BERRYS BAY STUDIO

Objection: SSD-93020230

40 – 48 Redan St, MOSMAN

On behalf of Neighbouring Residents

40-48 Redan Street, Mosman 40-48 Redan Street Mosman NSW 2088	Section 3 EW South Sections	Rev	Date	Description	By	Chk	Scale	Code	Sheet	Rev	0 2.5 5 10m	
		B	27/2/2026	SSD Submission - Lodgment	IS	1:250 @ A3	TPRS	4002	B

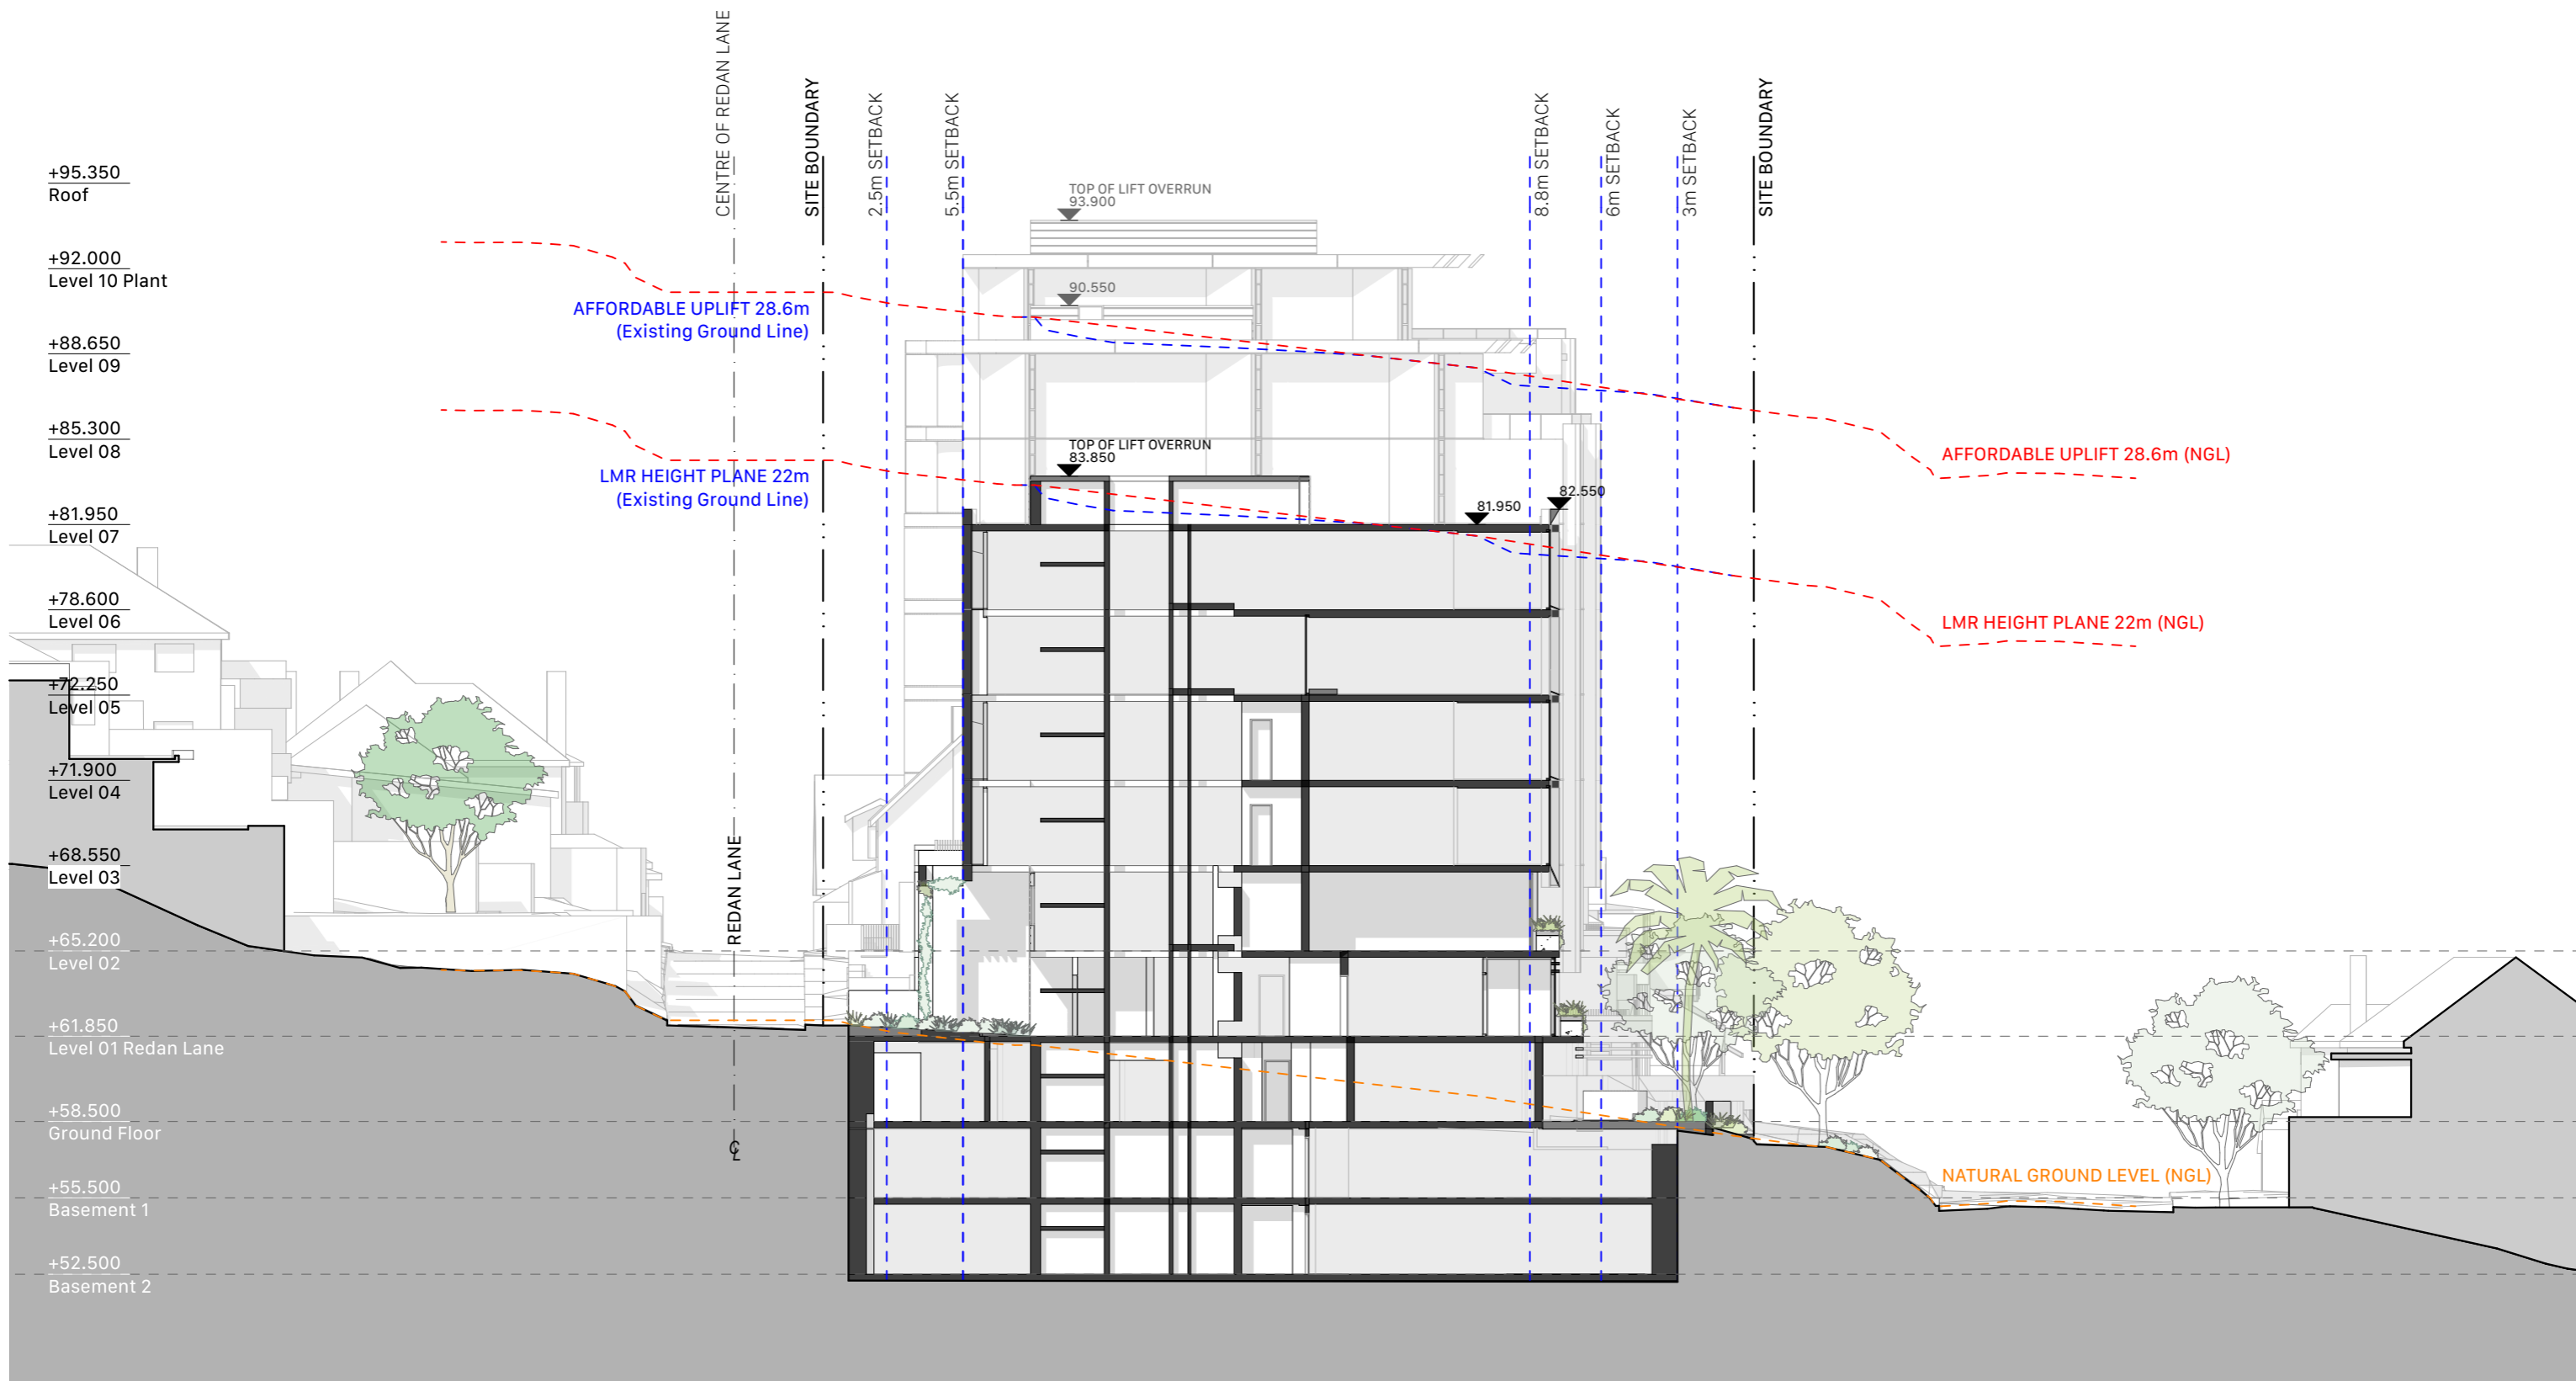
Even with the application of the Low to Mid-Rise (LMR) provisions and a 30% affordable housing bonus—which brings the maximum permissible building height to 22.75m—the proposal significantly exceeds this limit. The northern portion of the building reaches an overall height of 33.4m to the top of the lift overrun and 32.2m to the parapet. This represents a variation of up to 10.65m, exceeding the absolute maximum allowable height by 46.8%. The central portion also breaches the control, reaching 30.2m (a 32.7% exceedance).

The site is zoned R3 Medium Density Residential with a mapped maximum building height of 8.5m and a corresponding wall height control of 7.2m under the Mosman LEP 2012. The proposed development completely disregards this local standard. The proposed wall heights reach 32.2m in the northern portion, 30.4m in the central portion, and 23.5m in the southern portion. These represent extreme departures of 25m, 23.2m, and 16.3m respectively from the 7.2m control.
